Report of the meeting of the Development Control Post-Committee Site Inspection Panel held on

REF NO: B/36/10/

LOCATION: Thomas Cottage
104 The Splash
Wepham

PROPOSAL: Revisions to tree house refused under reference B/14/10

EAST ELEVATION AS PROPOSED

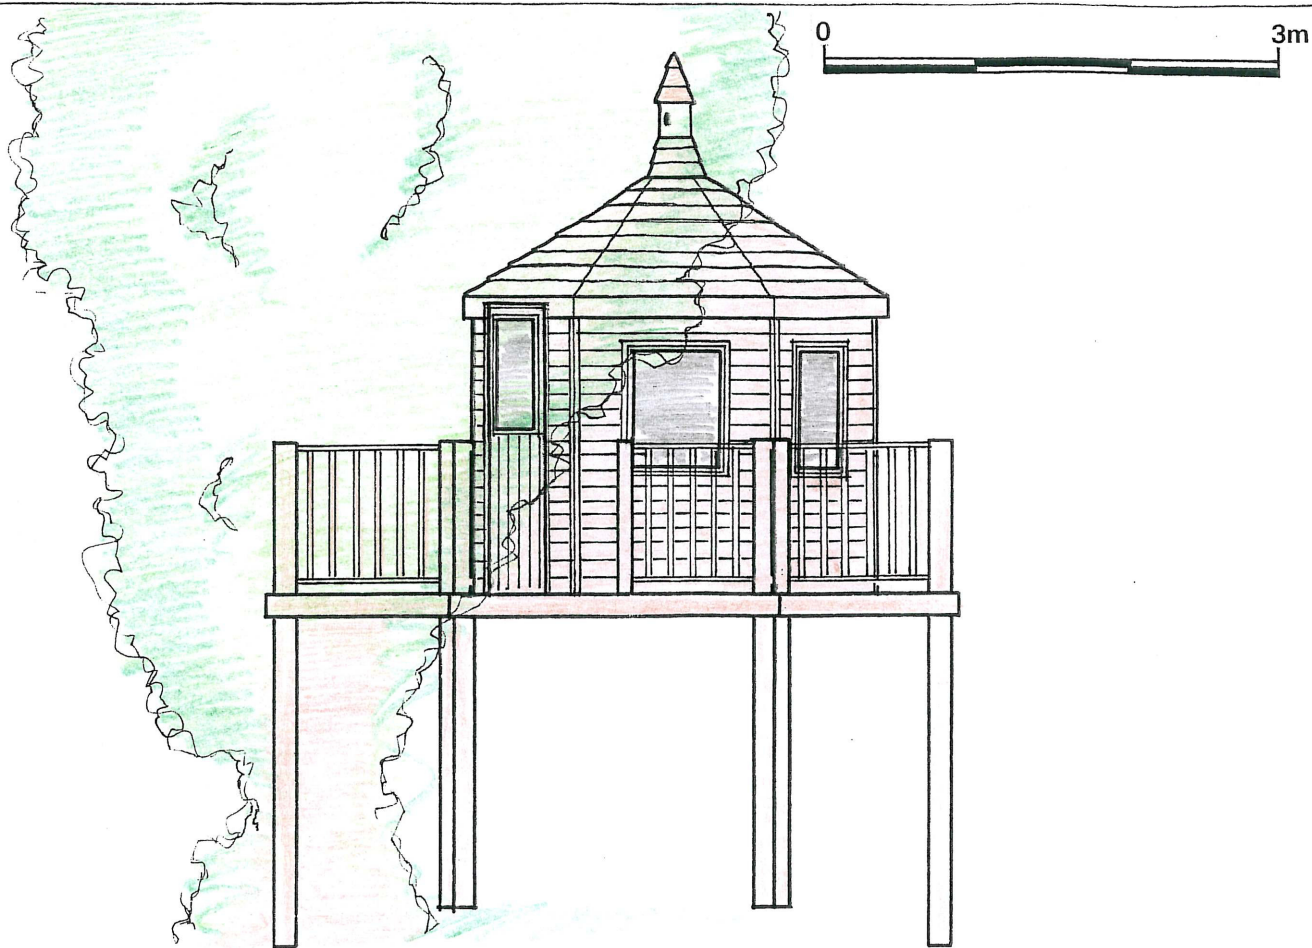
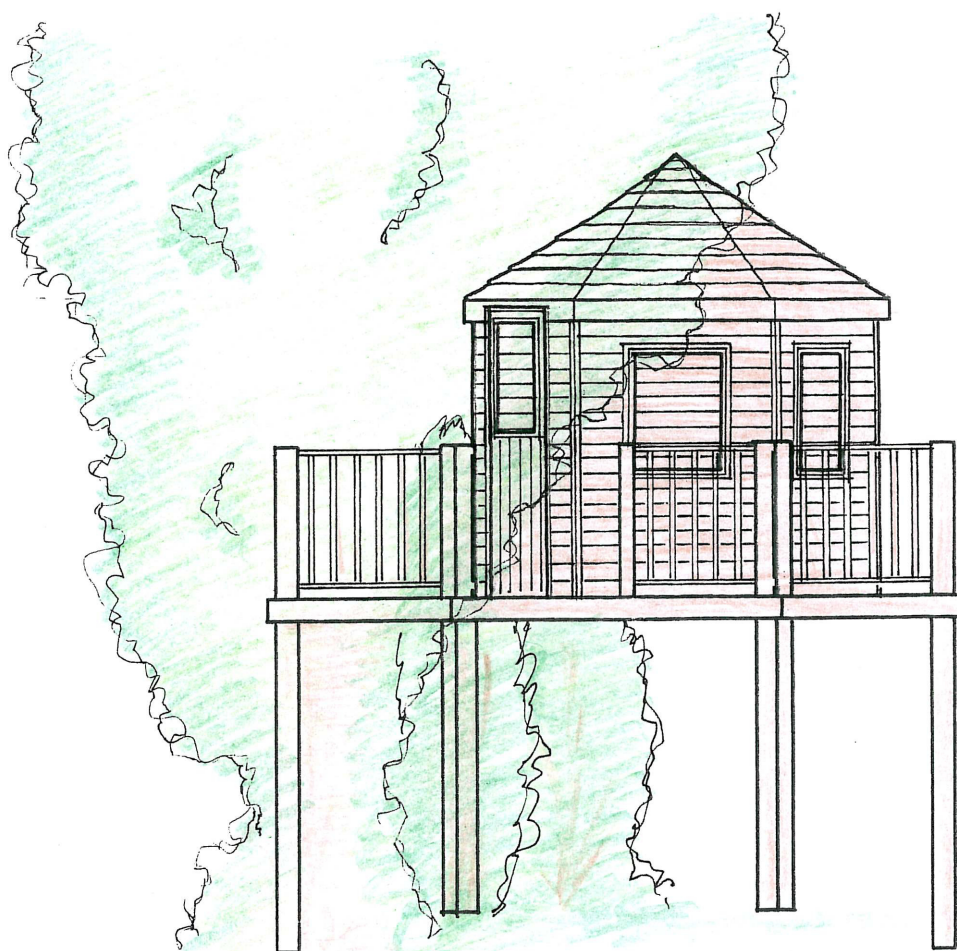
The alterations proposed are a minor attempt to reduce the scale of the structure but do not ultimately change its form and appearance. Changes in design are minimal and changes in scale are equally minor. Consequently the revised tree house remains a highly engineered building on stilts and not a tree house in the traditional sense which sits within the boughs of a tree. Therefore in accordance with the Inspectors appeal decision the revised tree house remains an engineered and alien structure, unacceptable in design terms and detrimental to the character and appearance of the locality.

The siting of the tree house remains close to the boundary which is highly exposed due to the boundary being formed by low level post and wire fencing. As set out above the alterations to the tree house are minimal and the tree house would remain highly visible when viewed from the surrounding countryside particularly in winter months when there is a complete lack of foliage. The proposal would appear as a harmful intrusion in the countryside and represents an undesirable form of development within the National Park which should be resisted. The Council is further concerned that the tree house fails to preserve or enhance the rural appearance of the
